Re: *Hein Preliminary Short Plat (SP-20-0004)*  
*Applicant's Responses to Short Plat Application Comments*

This firm represents applicant Hein & Hein Enterprises, LLC ("Hein" or "Applicant") under the above-noted Short Plat Application now pending with Kittitas County (the "Application"). Thank you for your letter dated August 21, 2020, and referenced documents concerning Application comments recently received from the Washington State Department of Fish and Wildlife ("WDFW") and from the Kittitas County Public Health Department ("County Health"). Applicant's responses to those comments are as follows:

LOT 4
30.09 ACRES

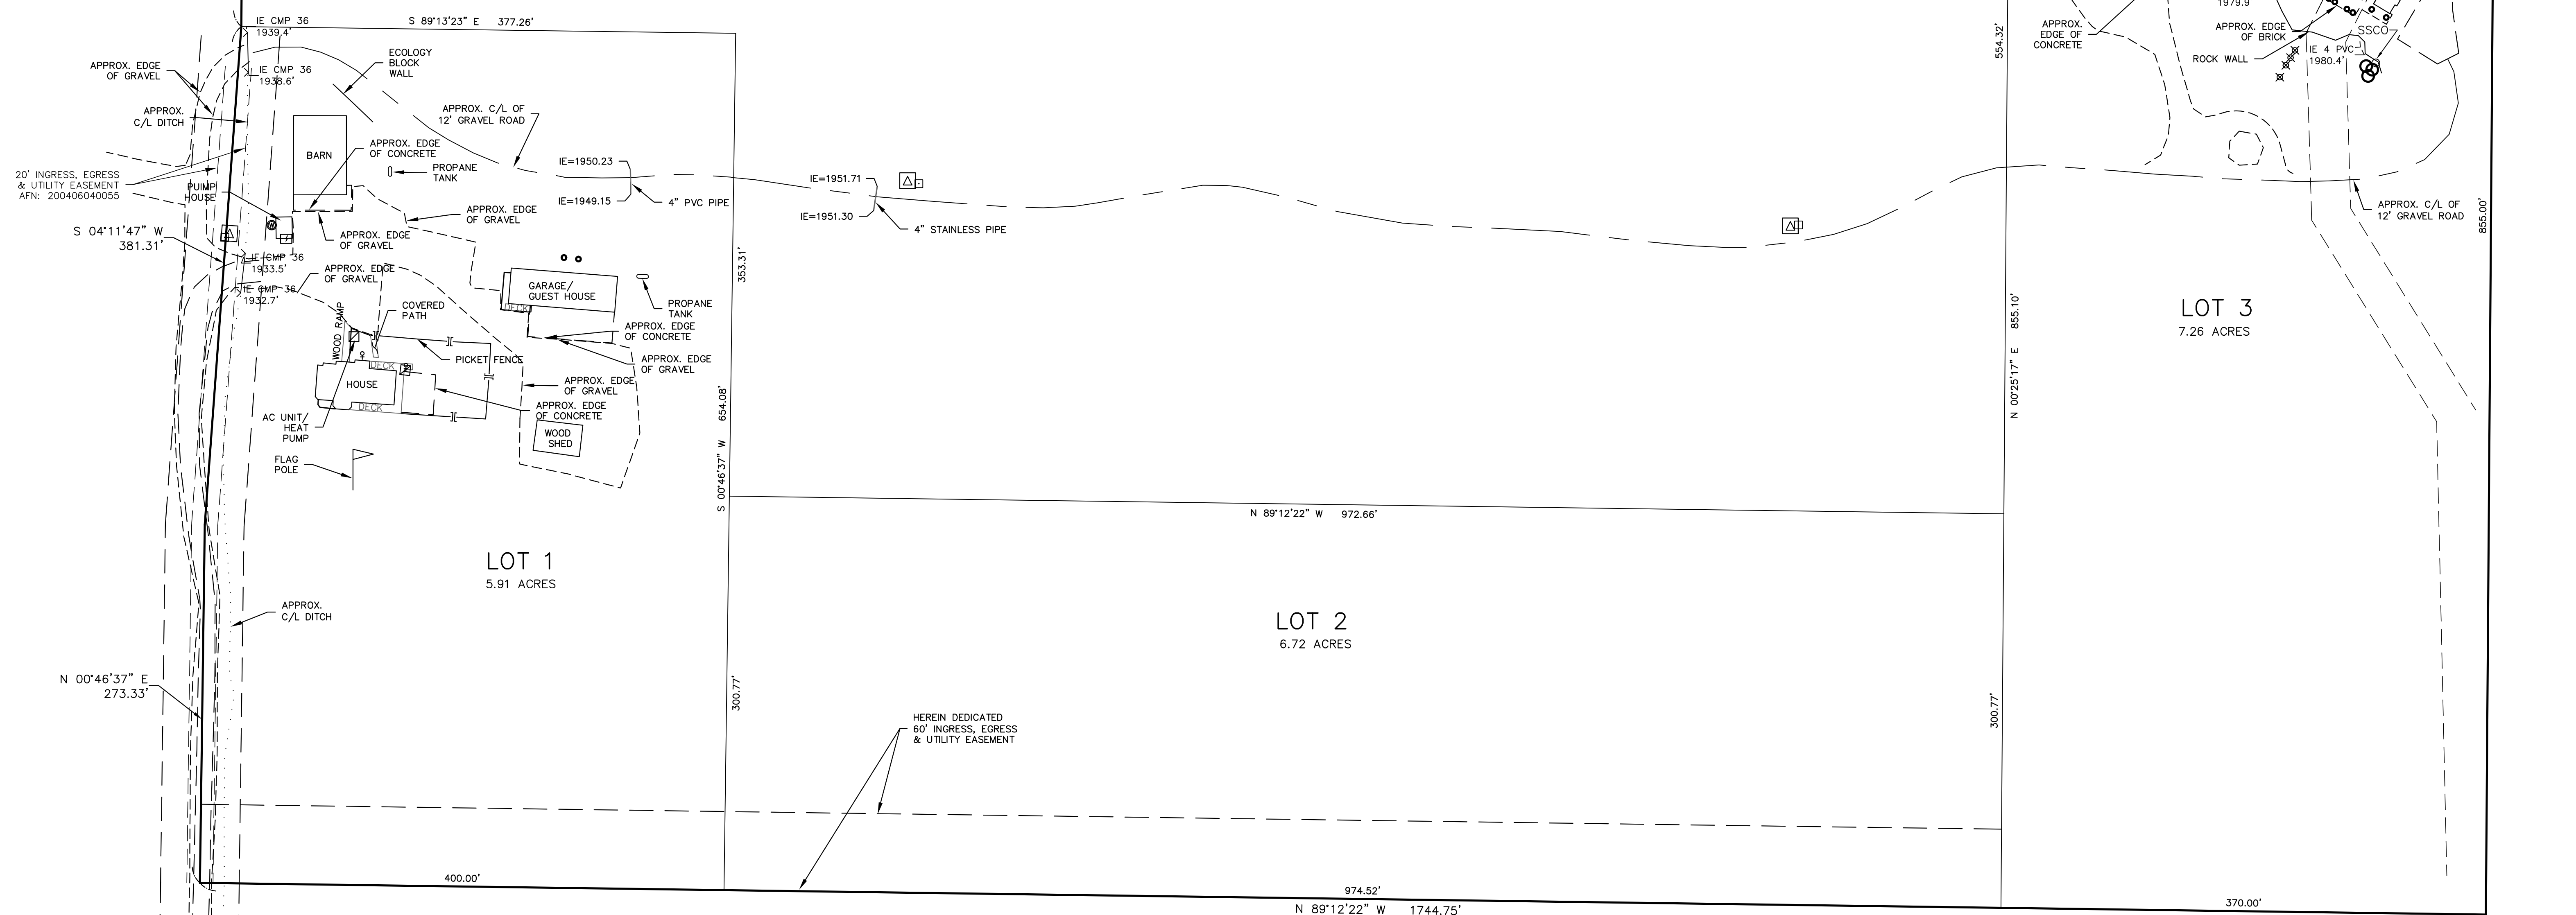
<sup>1</sup> A related issue – about which there is no dispute with WDFW – is the actual routing of the stream bed across lands within the proposed Short Plat. As we understand, WDFW agrees with findings under the Sewall Report that the stream bed runs parallel to and near the western boundary of the Short Plat, before meandering toward the southeast at a point south of the Short Plat. Stream bed routing as depicted in DNR "FPARS" online mapping is incorrect. The stream bed location as depicted on the originally submitted Application survey is correct and should be carried over to final Plat determination.

AIRPORT ROAD SHORT PLAT APPLICATION

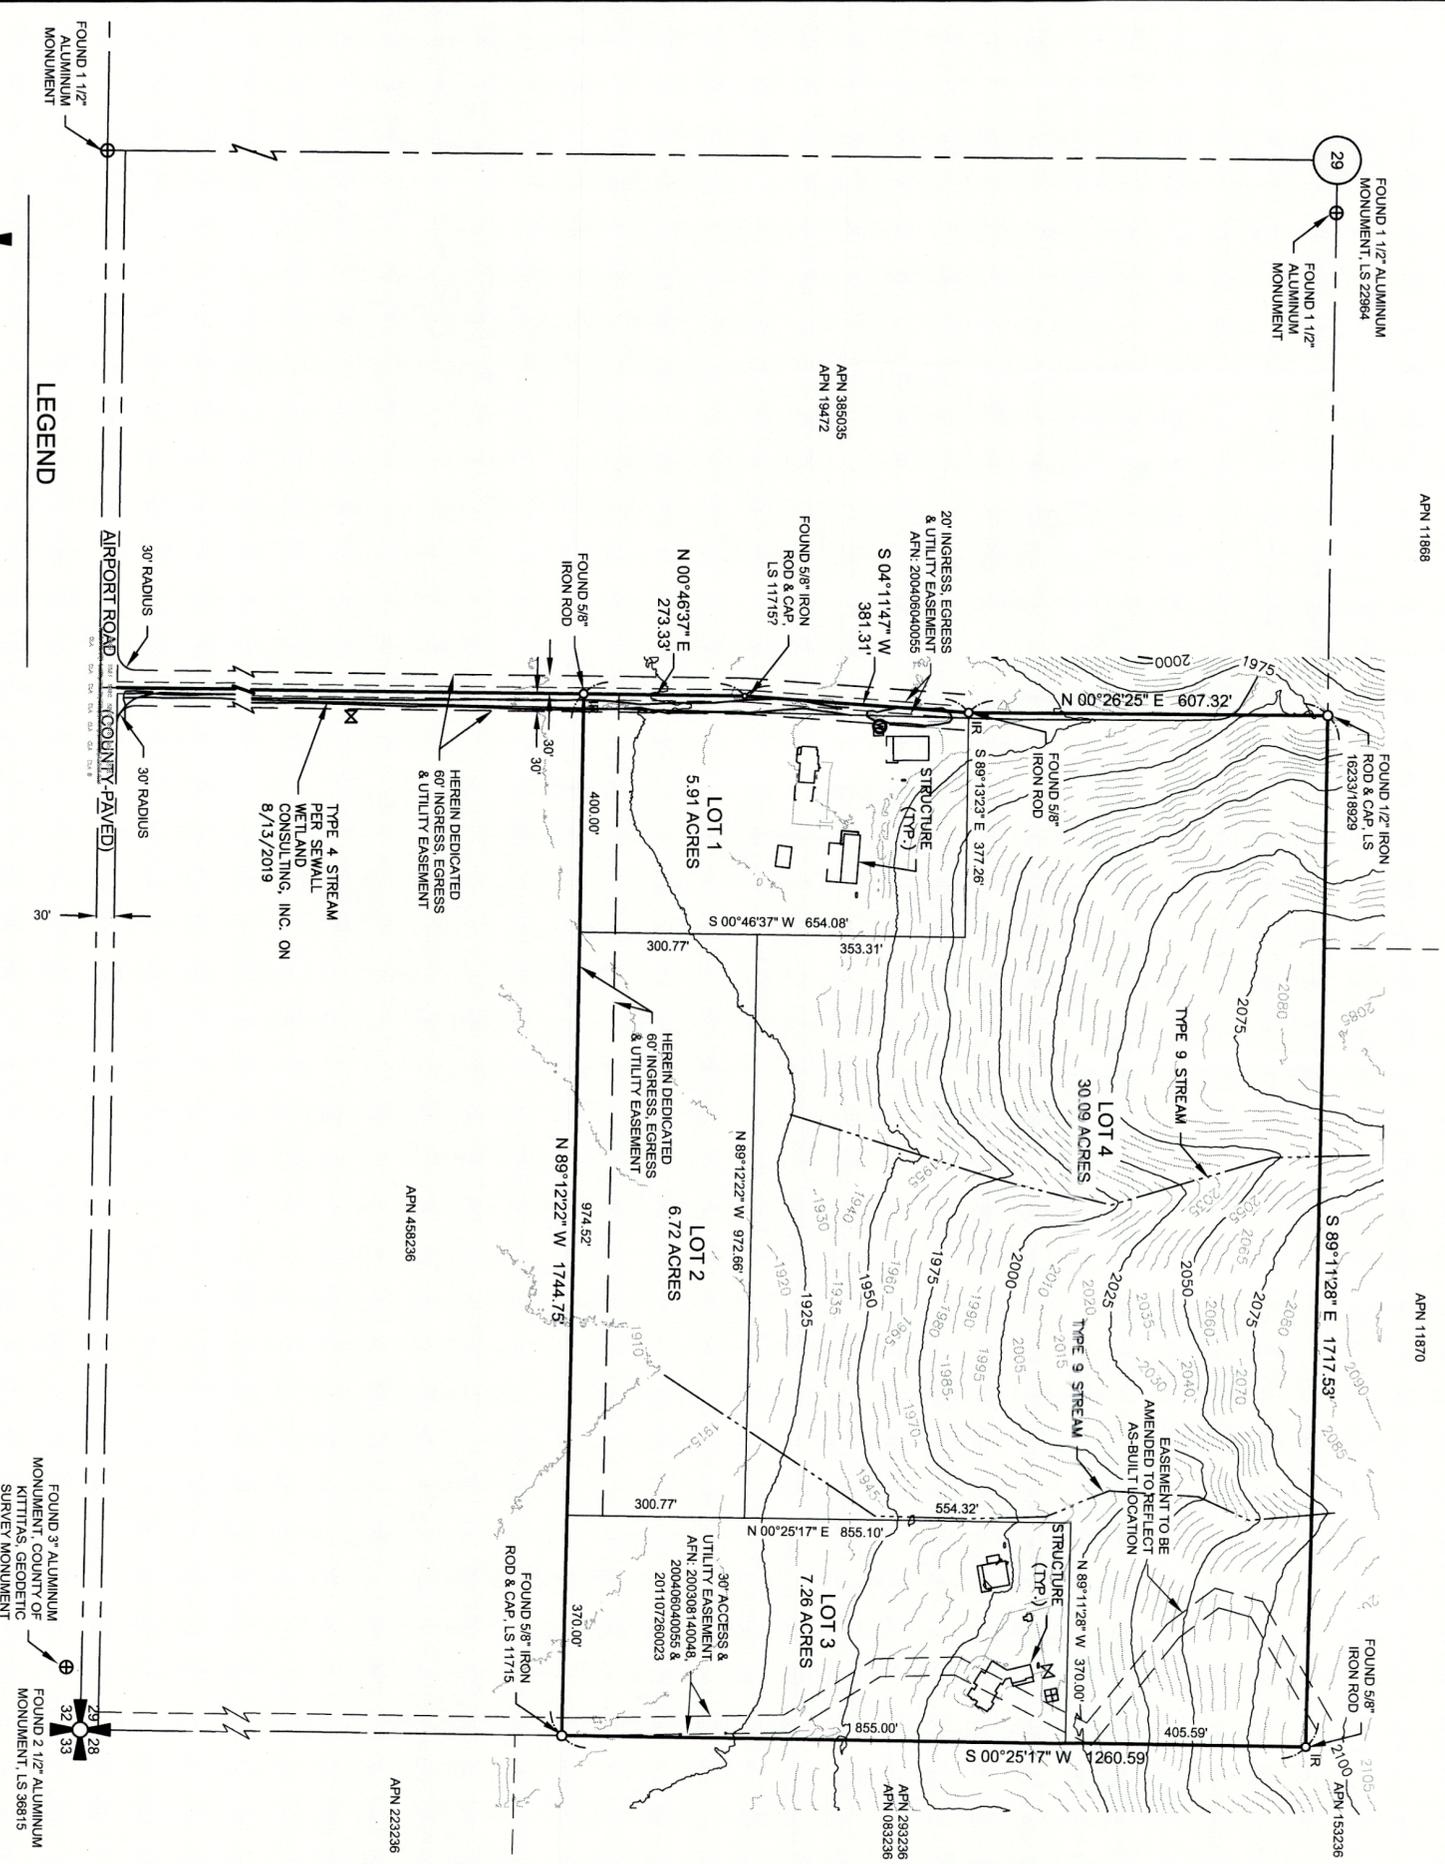
The other AWS consideration in this case is County Health's comment that Short Plat shared wells must be located a minimum of 50' from Lot boundary lines. We understand this is in response to guidance recently provided by County Counsel. We respectfully suggest that well location standards under KCC13.20.040 do not require 50' setbacks for shared wells, or for larger systems including Group B systems.

In our view, the above-quoted well location standards establish two separate – but not cumulative – requirements: one for individual wells and another for shared or two-party wells. If and to the extent Applicant determines to use the well on Lot 3 as a shared/two-party well with Lot 4, the above-quoted 100' sanitary control zone requirement for shared wells will apply. And because the subject well is located near the proposed Lot boundary line, portions of both Lots will be subject to the required control zone covenants. That said, KCC 13.20.040 separately confirms that the 50' setback requirement cited by County Health applies exclusively to individual water systems, i.e., to wells that serve only a single domestic connection.

In this case, Applicant's engineering consultant, Encompass, has separately confirmed with Ms. Erdman that County Health will not insist upon a 50' setback – presumably in

recognition of the fact that Applicant was unaware of County Counsel's interpretation of KCC 13.20.040 when the original Application survey was submitted.
